# Grading and Erosion Control Plan\_V1.pdf Markup Summary

# CIRCLE K AT HIGHWAY 24 & MERIDIAN ROAD GRADING & EROSION CONTROL PLANS

EL PASO COUNTY, CO  
MARCH 2022

SHEET 4 OF 7
GEC02

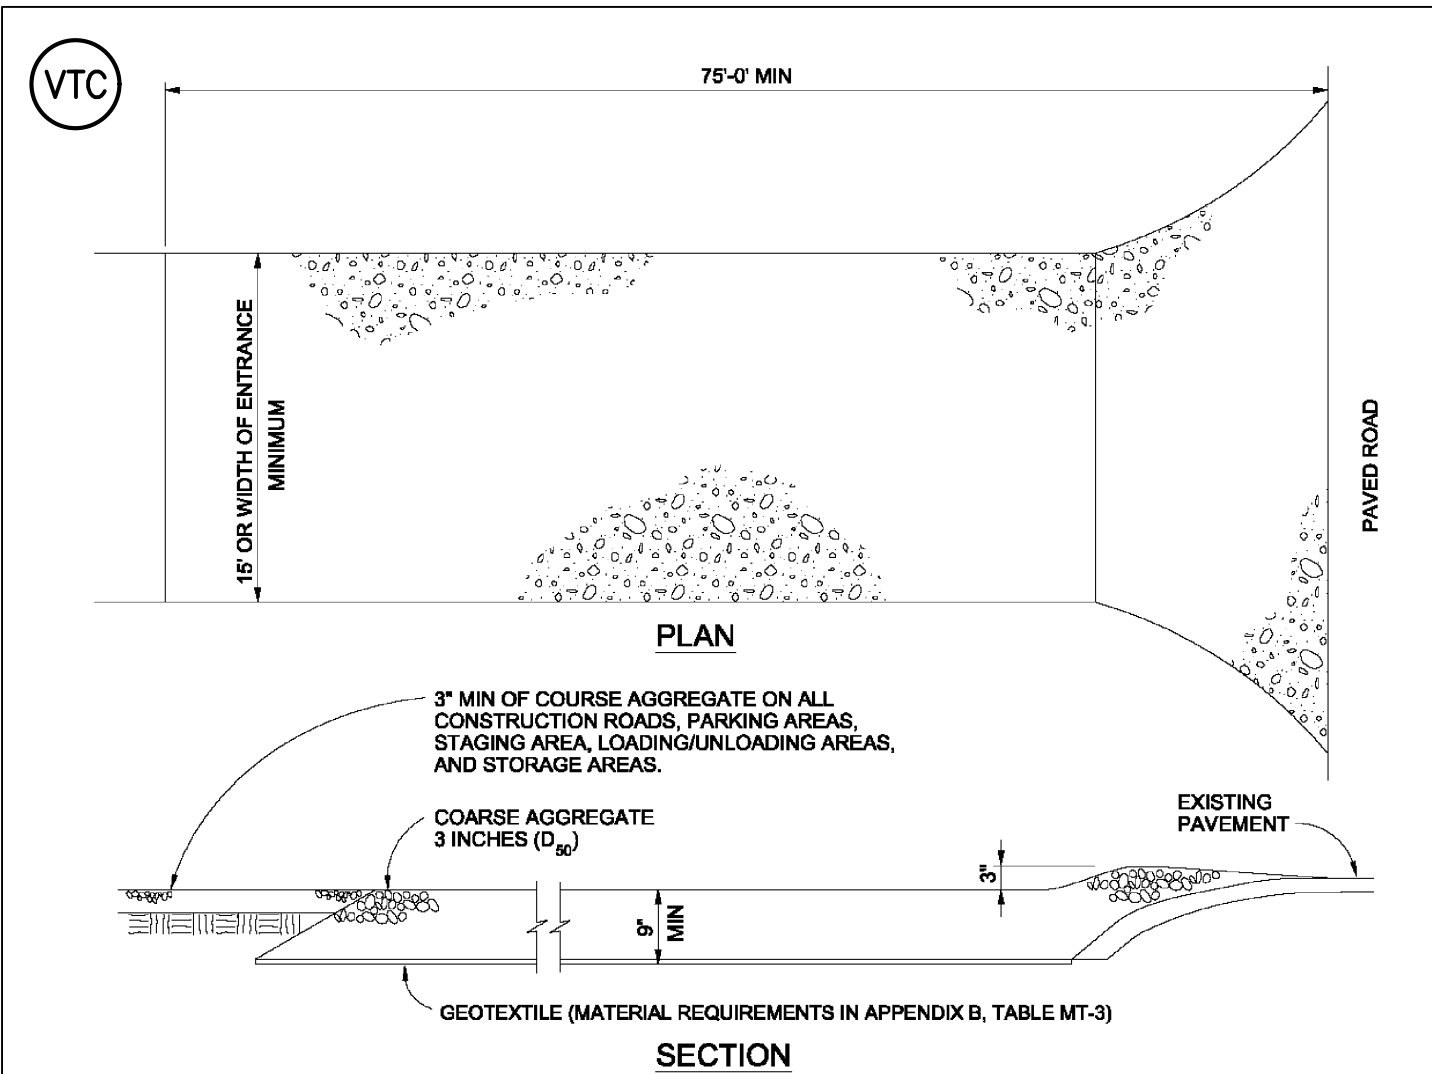
An outlet will be needed prior to when the EDB's outlet structure is fully constructed, just based on the sequencing of grading the pond, doing the concrete work, plus supply chain issues with securing well screens and orifice plates. So a TSB riser pipe will be needed.

DETENTION POND OUTLET  
STRUCTURE TO BE USED IN PLACE  
OF PERFORATED RISER PIPE

Show pond maintenance easement and/or label as a Tract.

Revise to 75ft min.

Revise to 75ft min.

Show rock socks along top of curb or within trickle channel (perpendicular to curbs), instead of placing straw wattles along edge of trickle channel curb like is done at most ponds. This will save time with re-vegetation effort later because once the straw wattles are removed, backfill and re-vegetation is needed behind back of curbs. Whereas with rock socks in or along trickle channel, the extra effort post-BMP removal would not be necessary.

Figure VT-2
VEHICLE TRACKING
CITY OF COLORADO SPRINGS
STORMWATER QUALITY

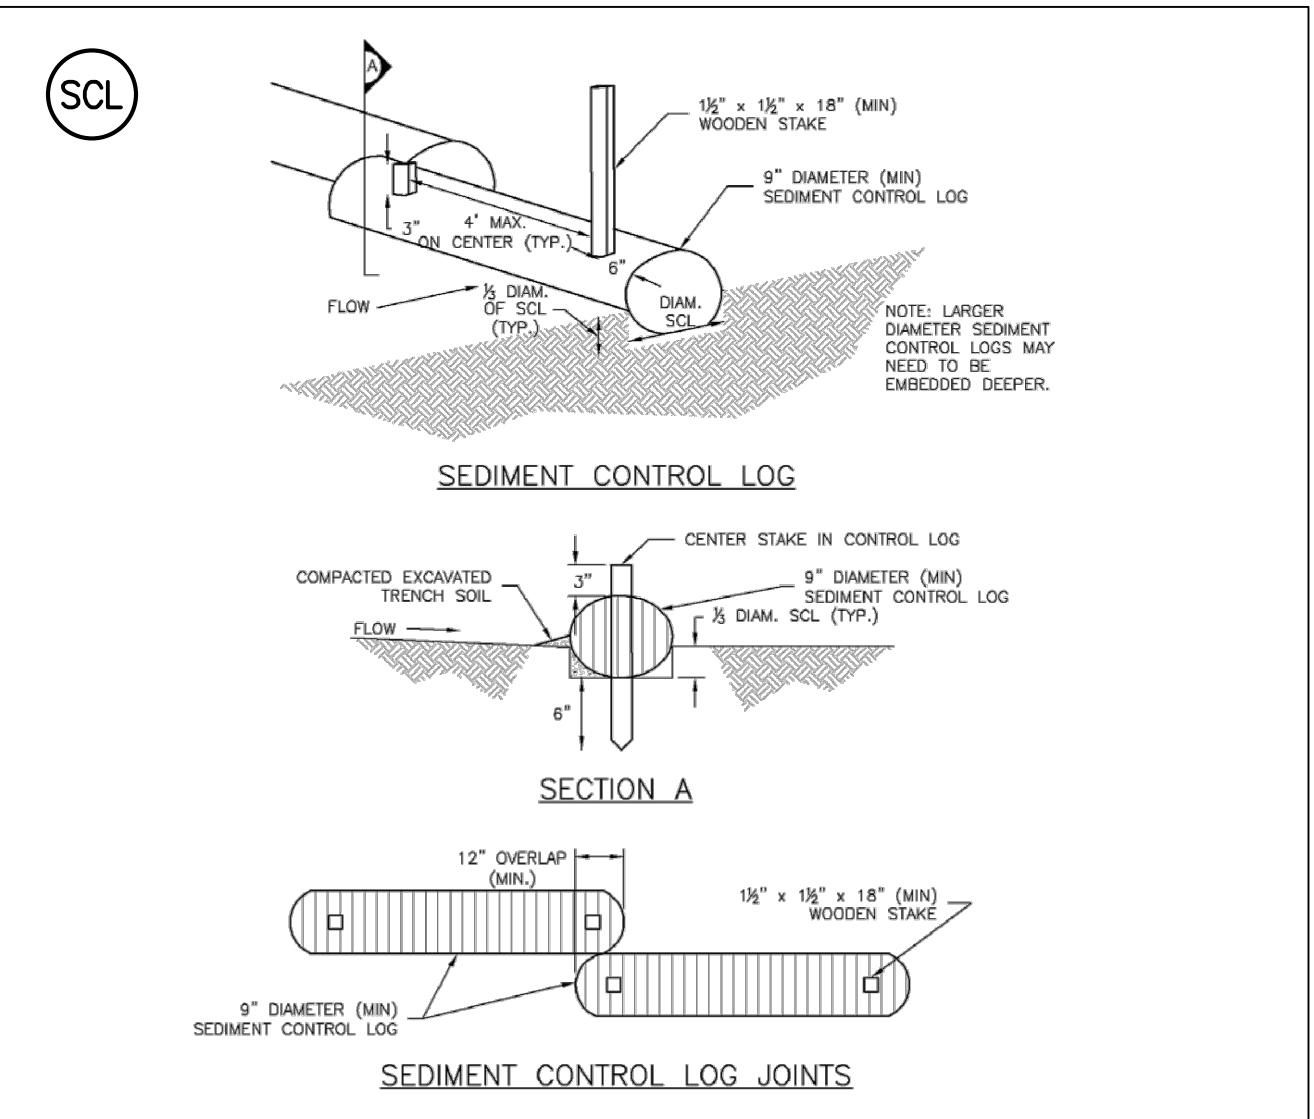
replace with EPC approved VTC detail (VT-1 and VT-2 in DCMv2, Chap 3.3) or revise to be 75ft min length.
